# Norfolk Boreas Offshore Wind Farm Joint Position Statement with North Norfolk District Council Noise Sensitive Receptors

Applicant: Norfolk Boreas Limited  
Document Reference: ExA.AS-5.D6.V1  
Deadline 6

Date: March 2020  
Revision: Version 1  
Author: Royal HaskoningDHV

© Vattenfall Wind Power Ltd 2019. Contains Ordnance Survey data
© Crown copyright and database rights 2019 Ordnance Survey 0100031673

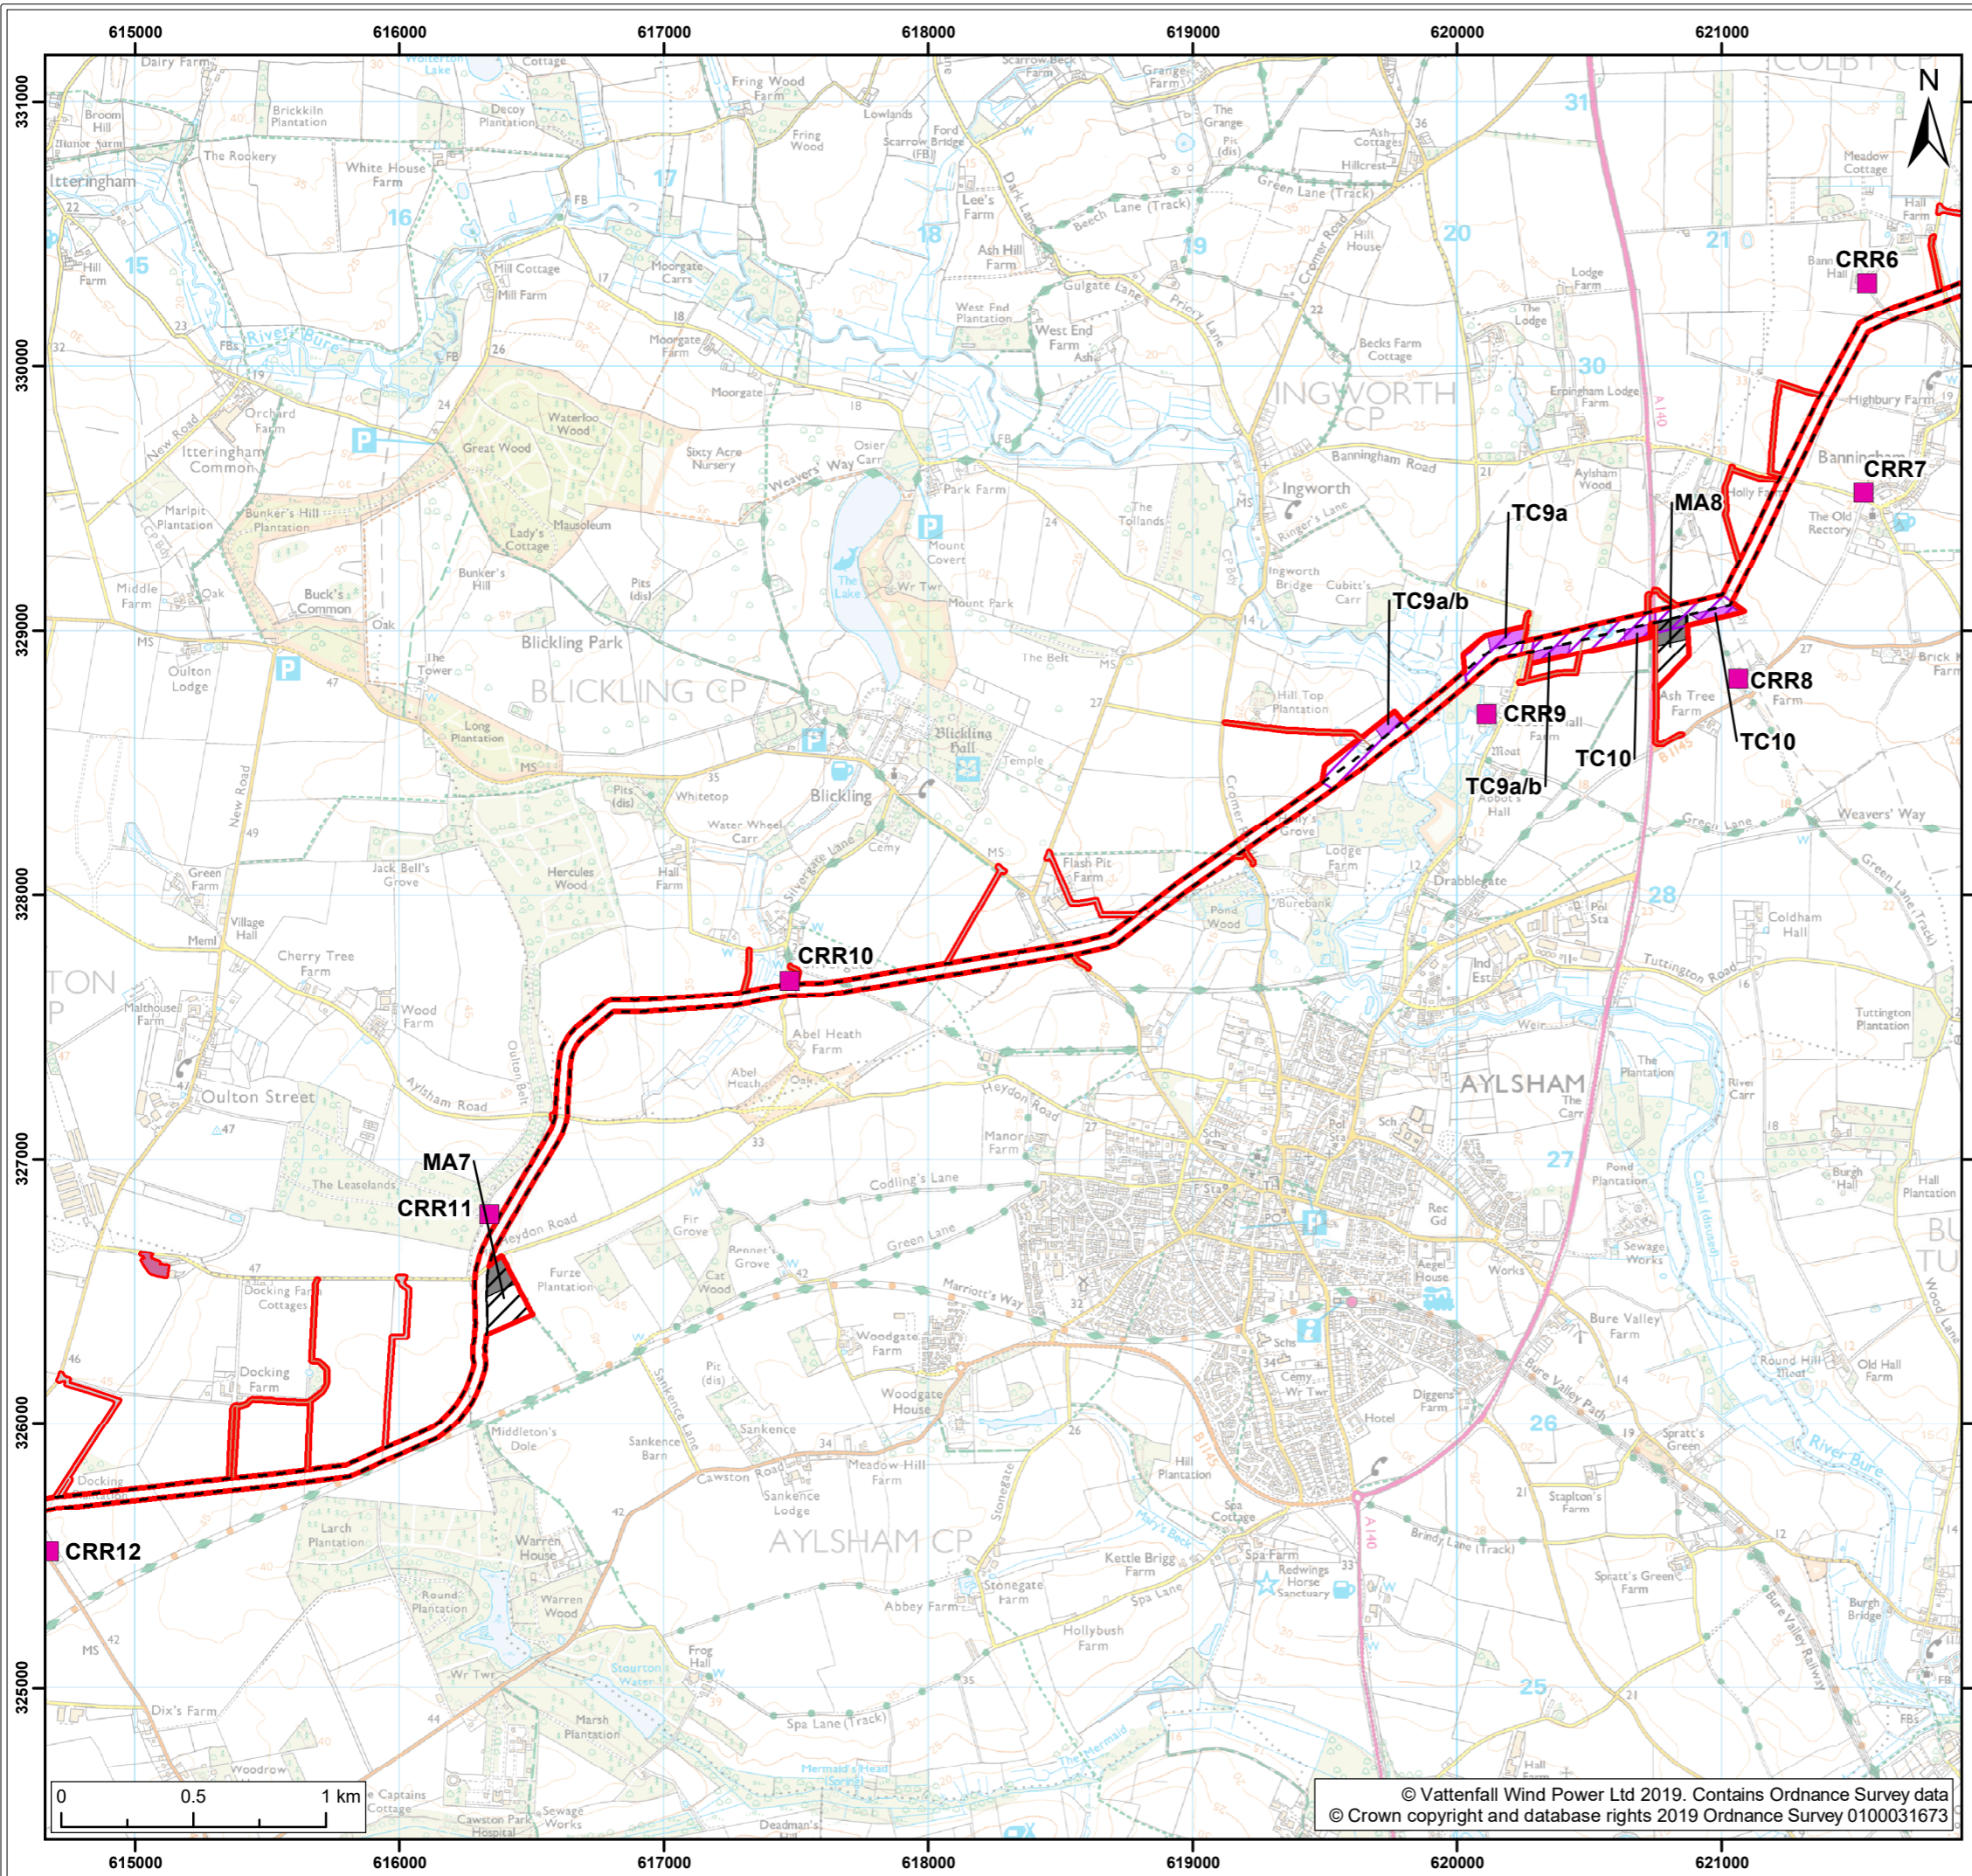
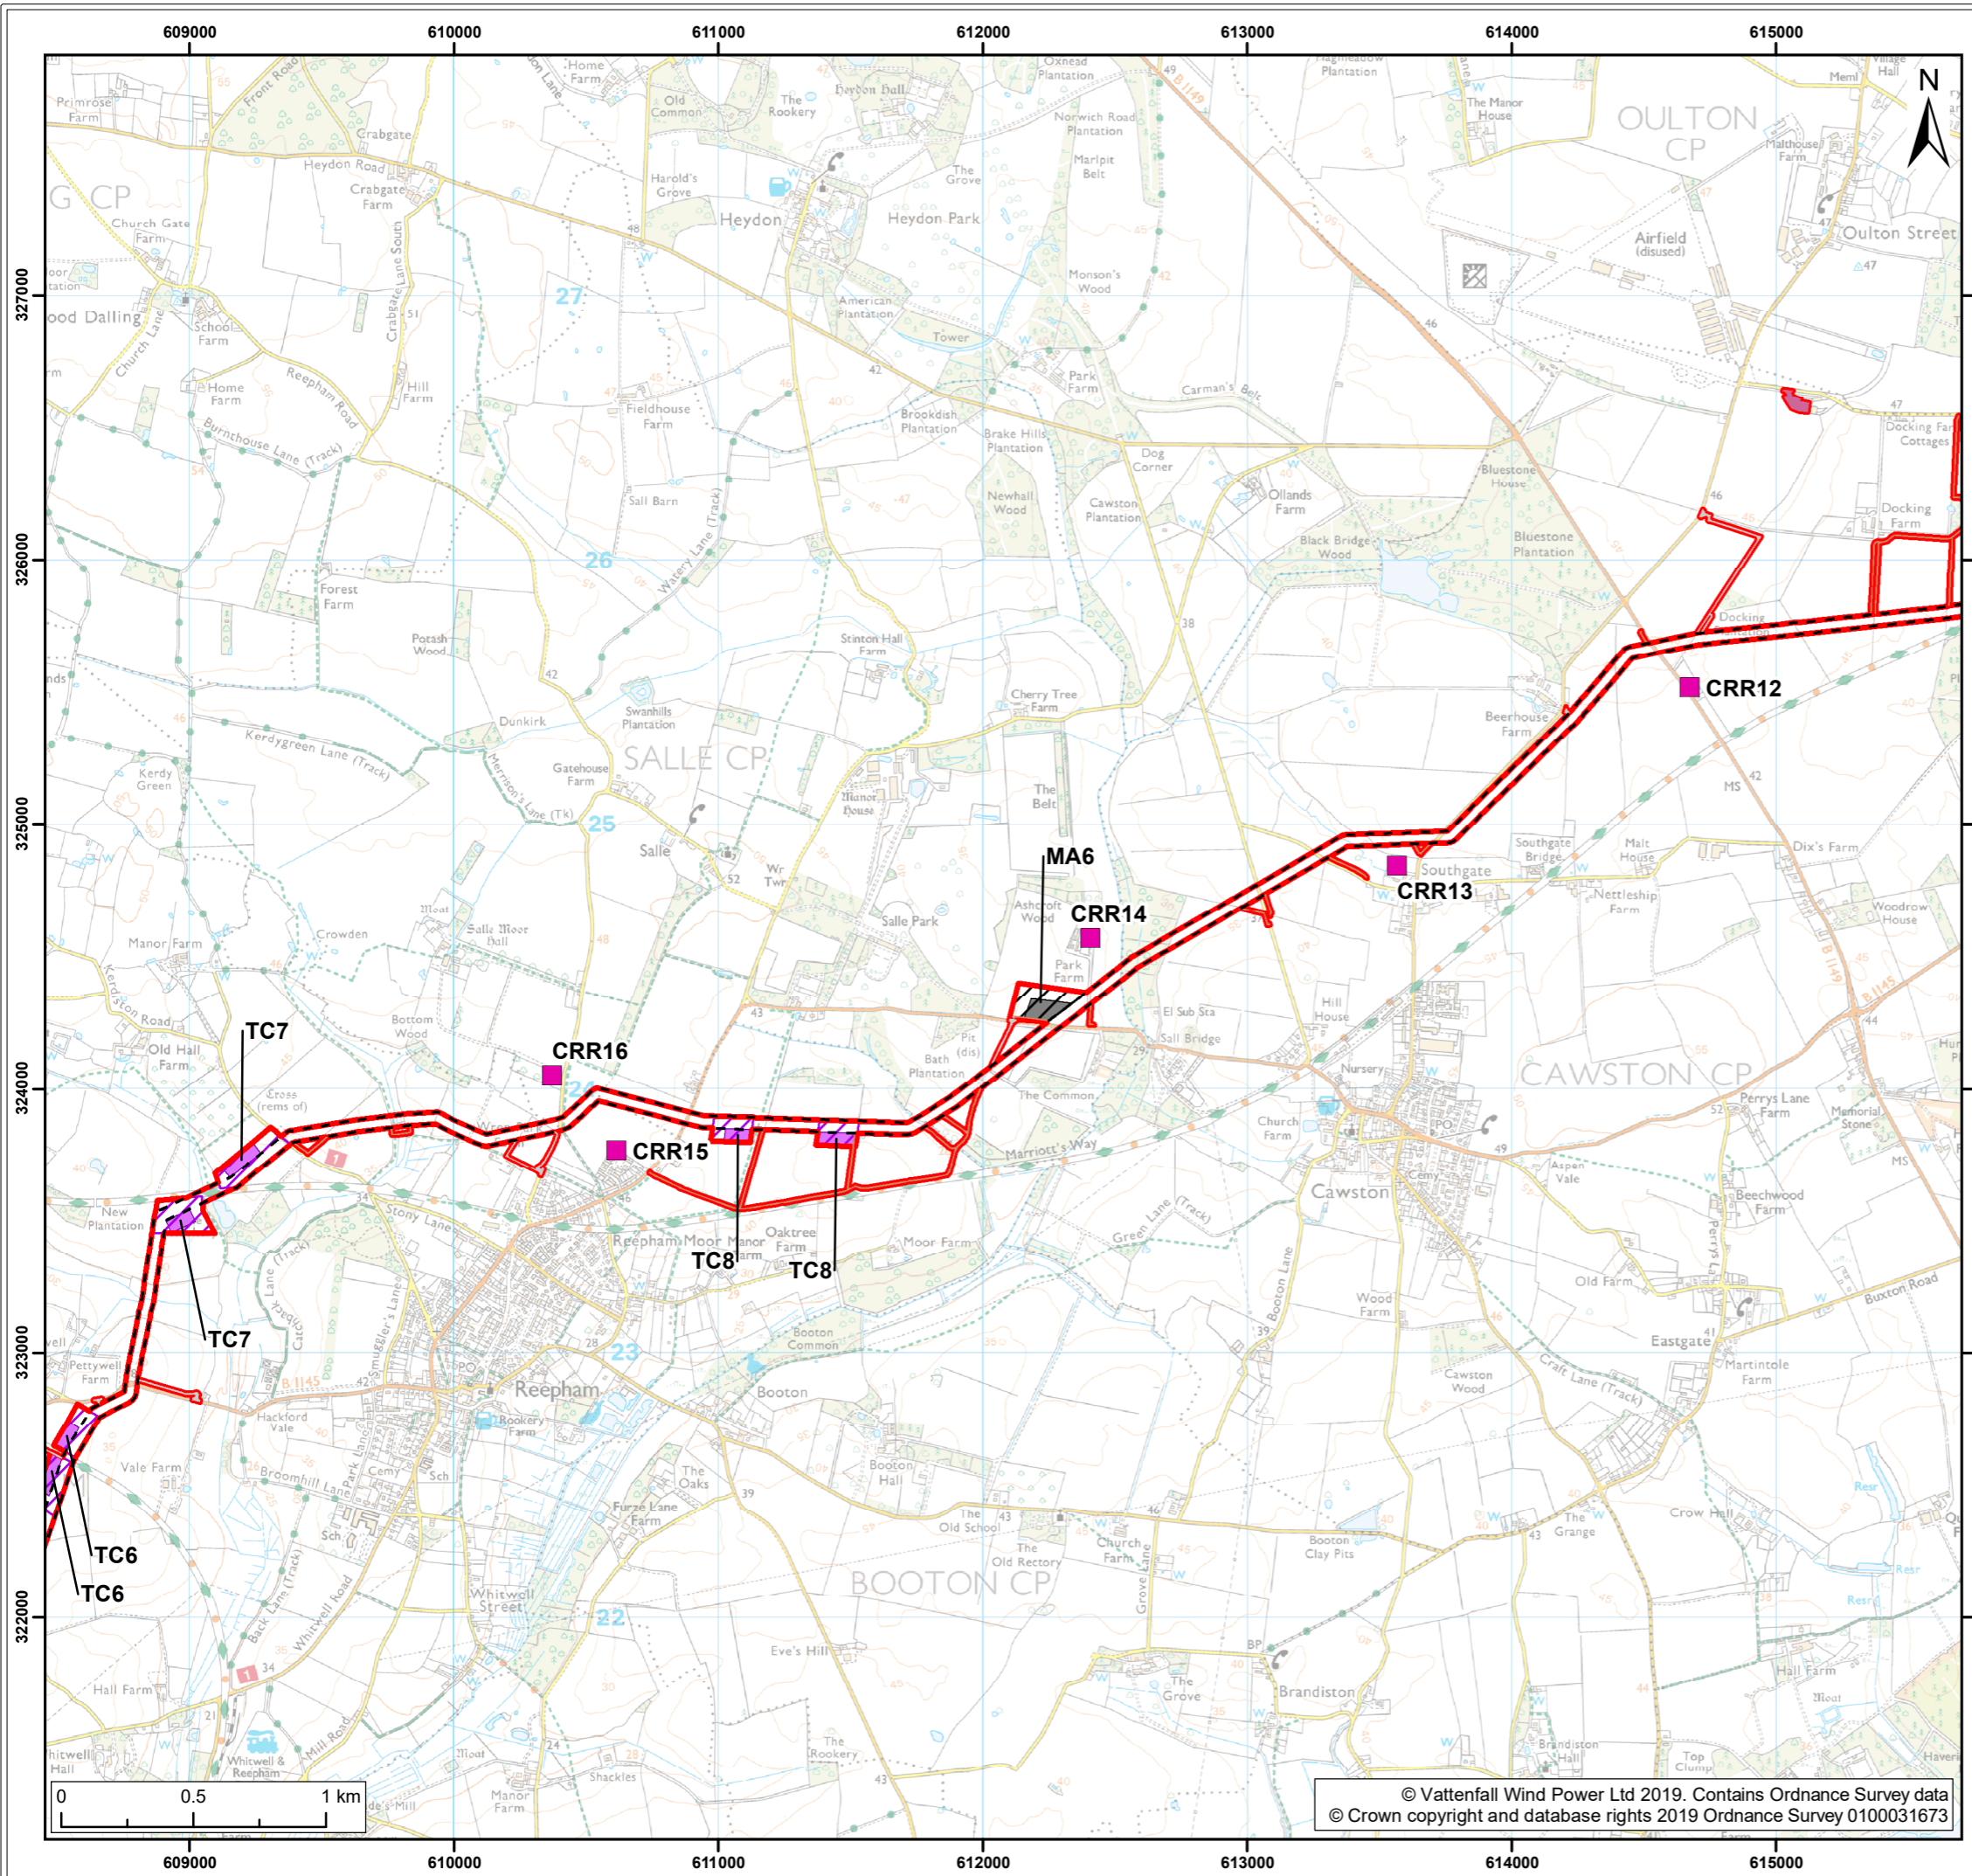
21. In terms of the locations set out above at paragraph 14 a) and b), whilst NNDC note these examples, the locations of which are set out in document 6.2.25.2 Environmental Statement - Figure 25.2 Noise Receptor Locations [APP-470], it would be helpful and clearer to all parties if these locations are also described by their address location (e.g. road name and village) and/or add map references.

- 3) In Table 1 Cycle routes to be identified as low sensitivity receptors rather than negligible.
  - 4) For the receptor locations identified as potentially requiring enhanced mitigation (in section 3.1) to also be described by their address location (e.g. road name and village) and/or add map references.

- ii. Provide additional detail on the receptor locations requiring enhanced mitigation to include road name and village and a map reference;
  - iii. Include additional text (as per Section 3.2) to confirm that the development of the CNMP will include a review of the construction activities and the identification of any potential noise sensitive receptors (as defined in Table 1) which may be affected and identify any potential control to minimise effects.
